**Mrs S Close
Seaview Avenue
East Preston
Littlehampton
West Sussex**

Your Ref :
Our Ref : EP/8/18/NMA

Application for a non-material amendment following a grant of planning permission EP/139/16/HH relating to the front door & window above
17 Seaview Avenue, East Preston, ,

I refer to your recent application for a Non Material Minor Amendment to change the aluminium glazed frontage, previously granted, with a uPVC window at first floor level, a uPVC entrance door at ground floor level and rendered elevations rather than Eternit weatherboard.

2 East (Front) Elevation Proposed
1 : 100

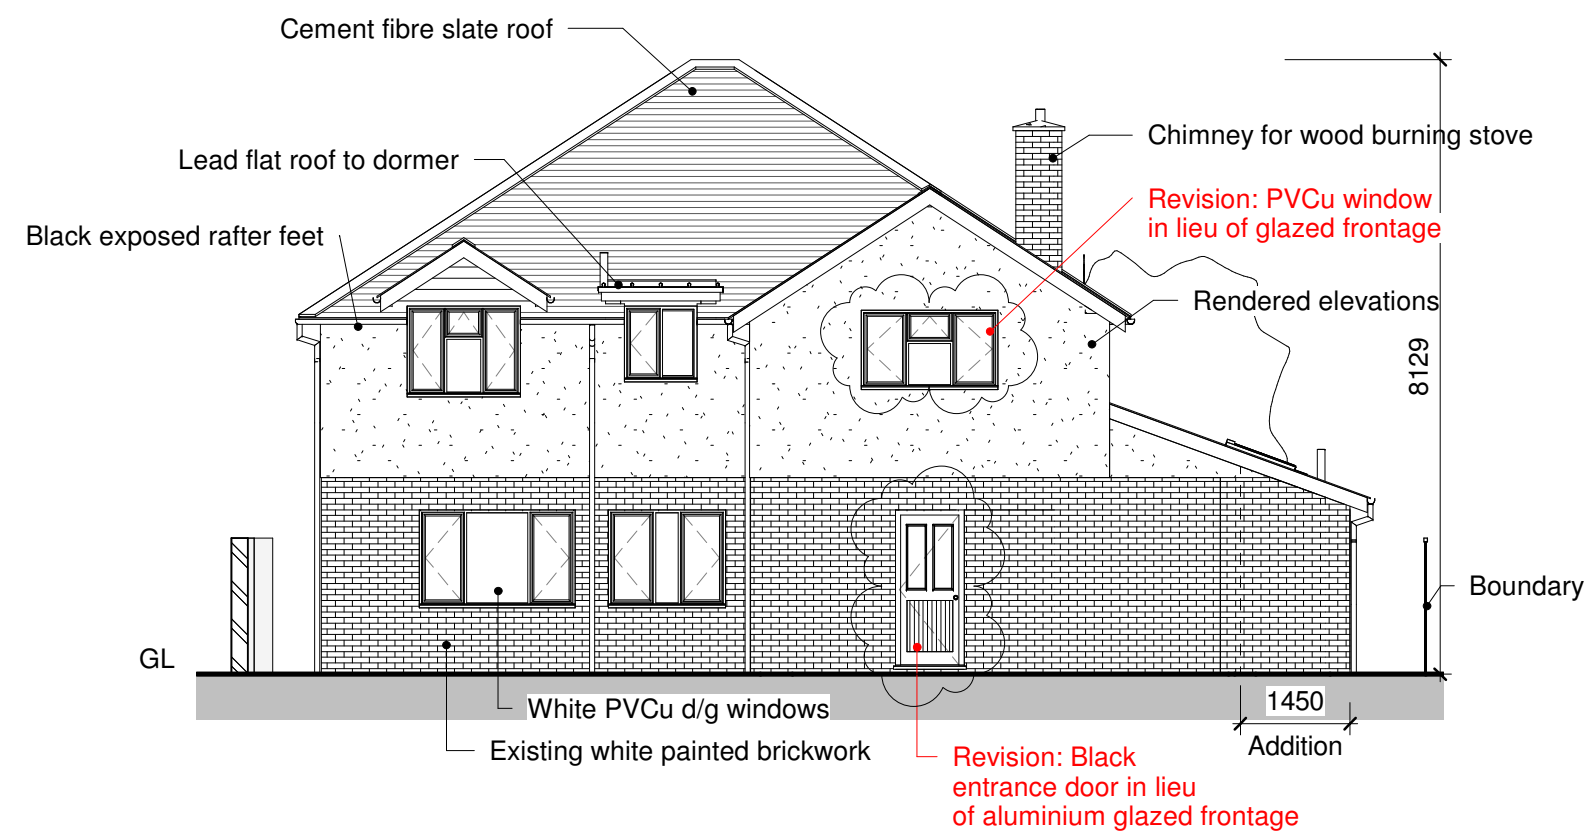
The reason that the have not been accepted as Non-Material Amendments is because it is considered that the proposals would result in changes to the external details that would materially alter the appearance of the building from that previously granted. Also it is noted that the removal of the glazing and addition of a window at first floor level along with the proposed alterations to the gallery landing would lead to window(s) that are introduced that could potentially permit overlooking of other properties. It is then considered that these amendments would warrant re-consultation of neighbours.

In this case It is considered that that it would be inappropriate to deal with the, aforementioned, changes as a Non-Material Amendment and they cannot therefore be considered under section 96A of the Town and Country Planning Act 1990.
